CITY OF PORTLAND, MAINE
DEVELOPMENT REVIEW APPLICATION
PLANNING DEPARTMENT PROCESSING FORM
DRC Copy

2006-0244
Application I. D. Number
12/28/2006
Application Date
13 Wall St / 1415 Forest Ave split lot
Project Name/Description

RE: C. of O. for #13 Wall Street,
(Id#2006-0244) (CBL 340 G 001001)

DRAWN BY: RTG / PJM
 CHECKED BY: PJM
 SCALE: 1"=40'
 DATE OF SURVEY: 07/24/2006
 JOB NUMBER: 2006071
 REV. 2 DATE: 10/10/2006
 SHEET: 2 OF 3

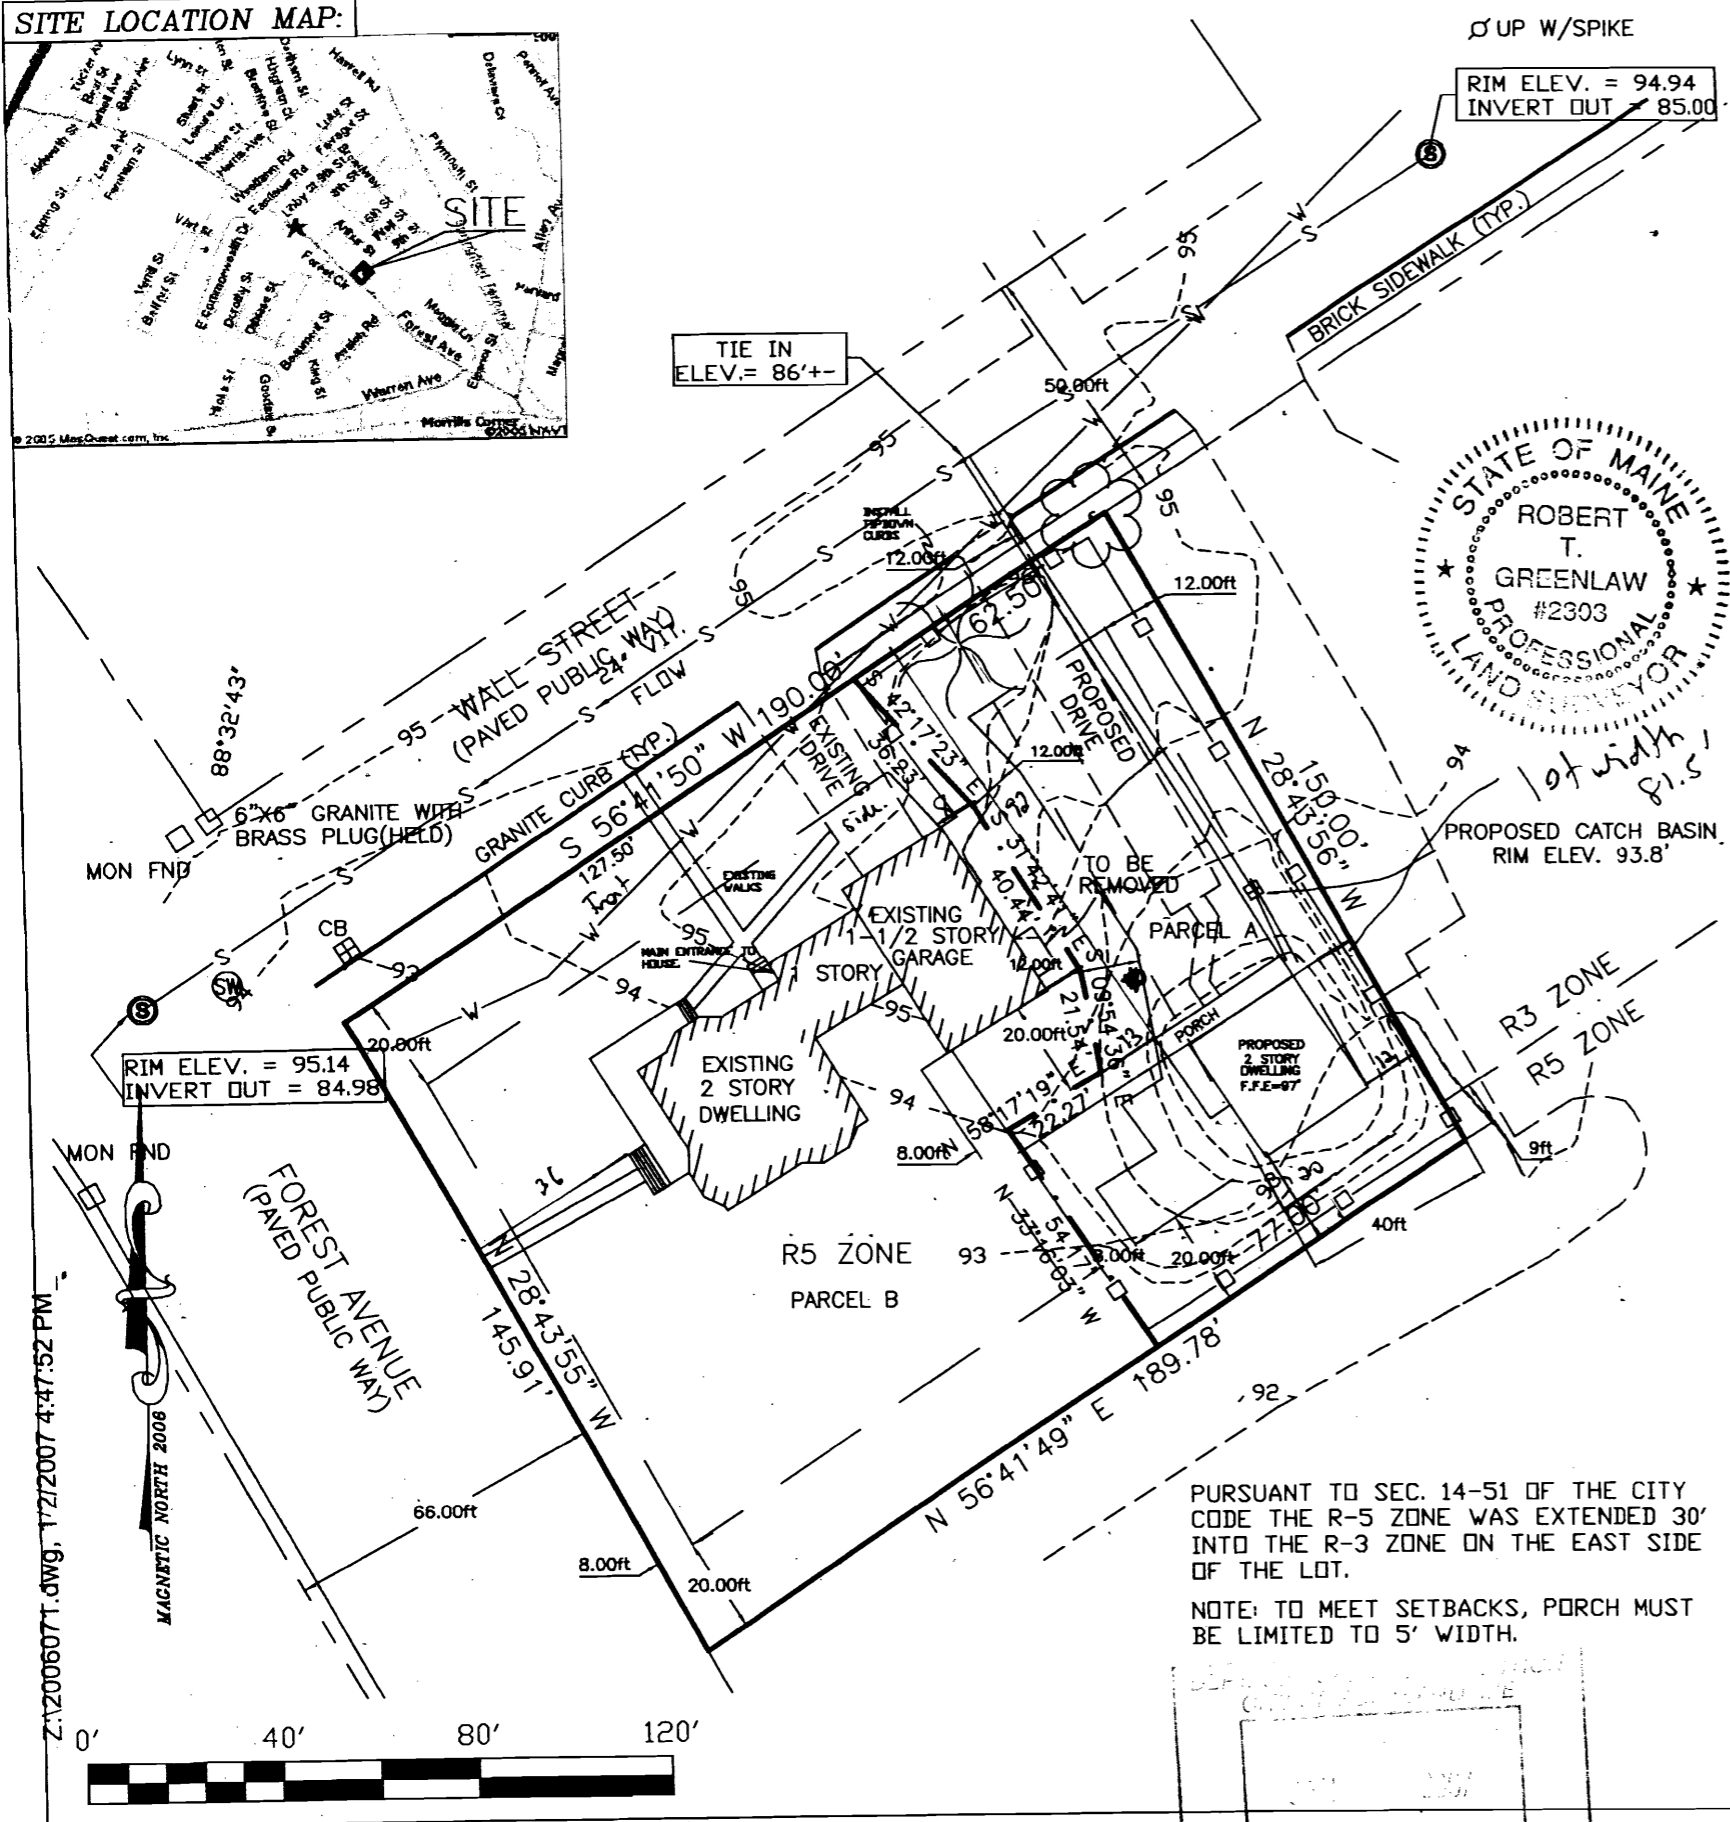
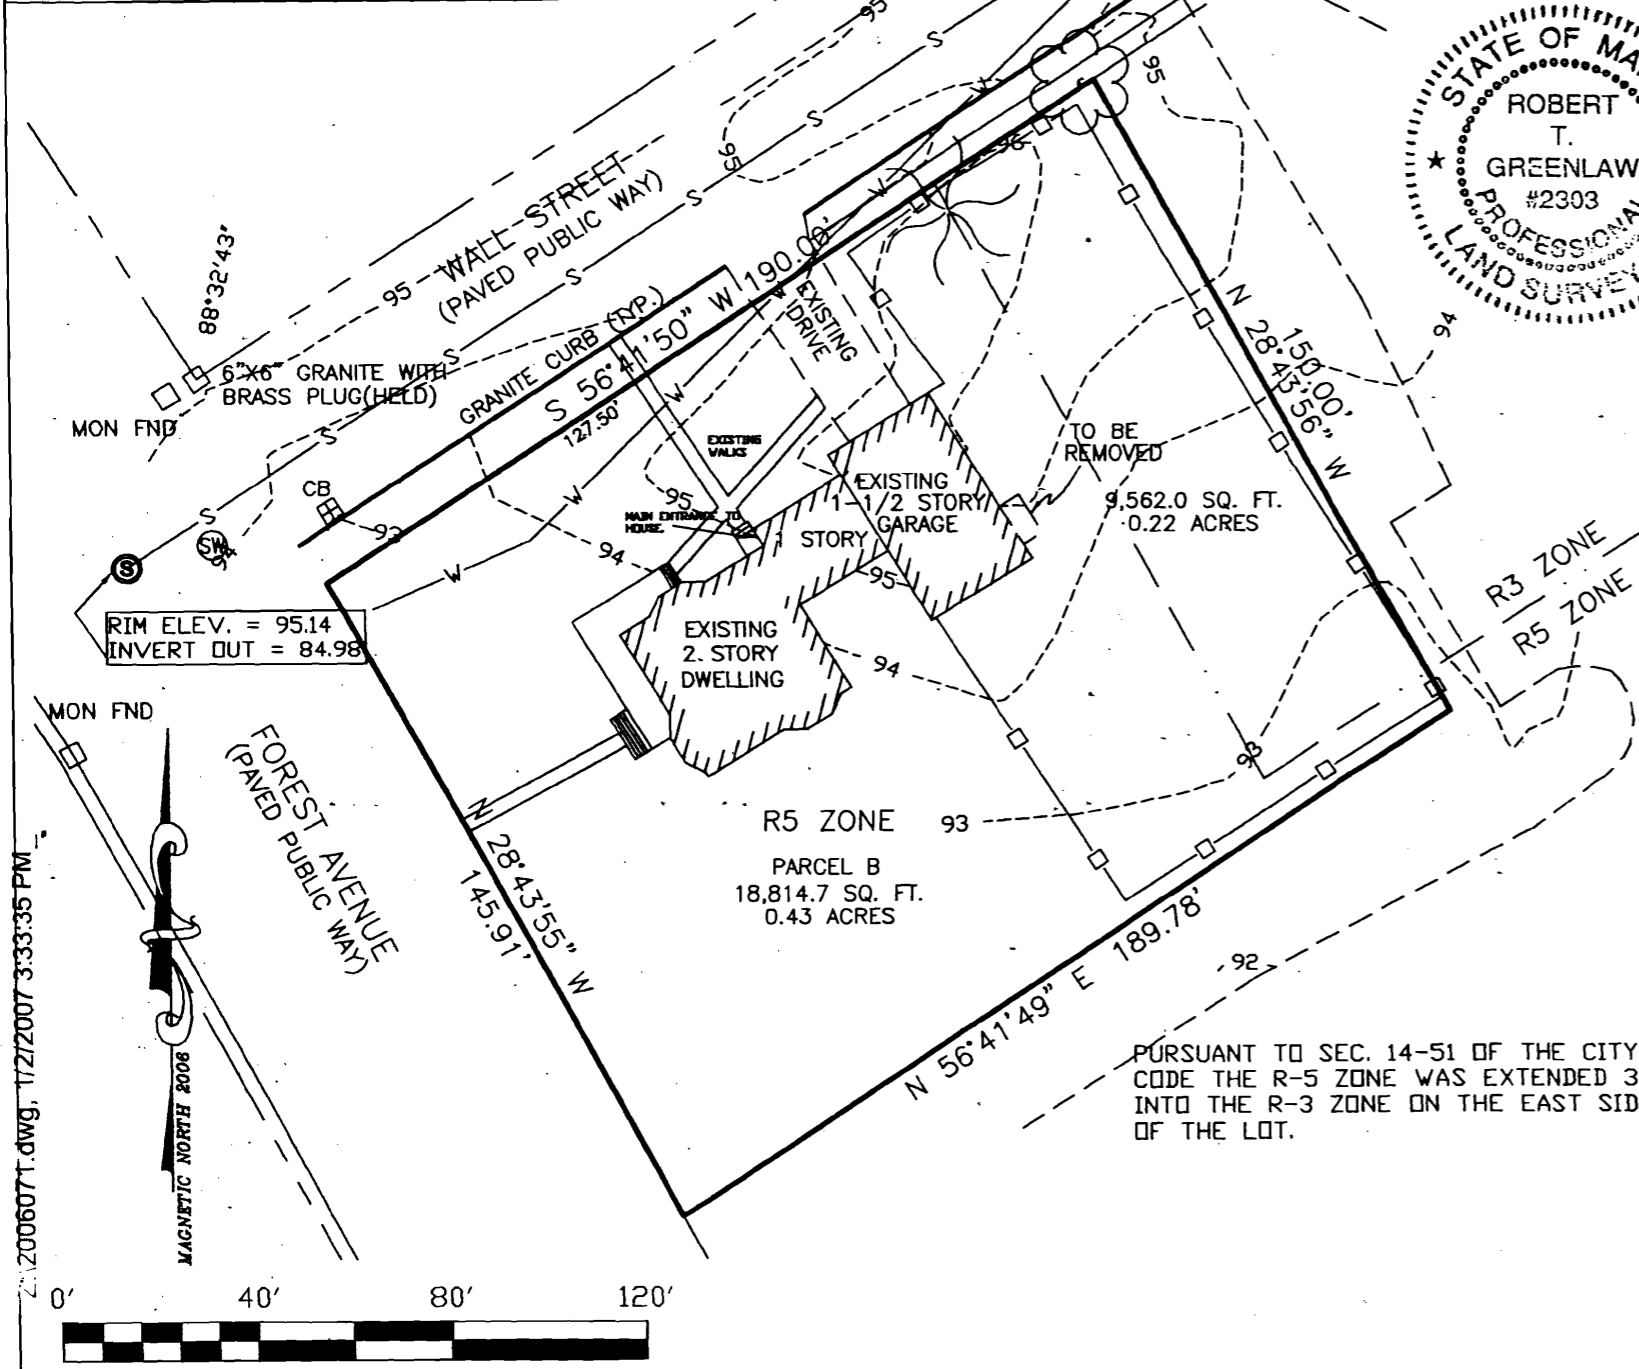
- Grading ≠ Finish grading per plan.
- 2 street trees
- loam & seed
- House numbers
- Foundation not built according to plans - stepped down in Right Rear corner.
- catch basin needs grate/cover
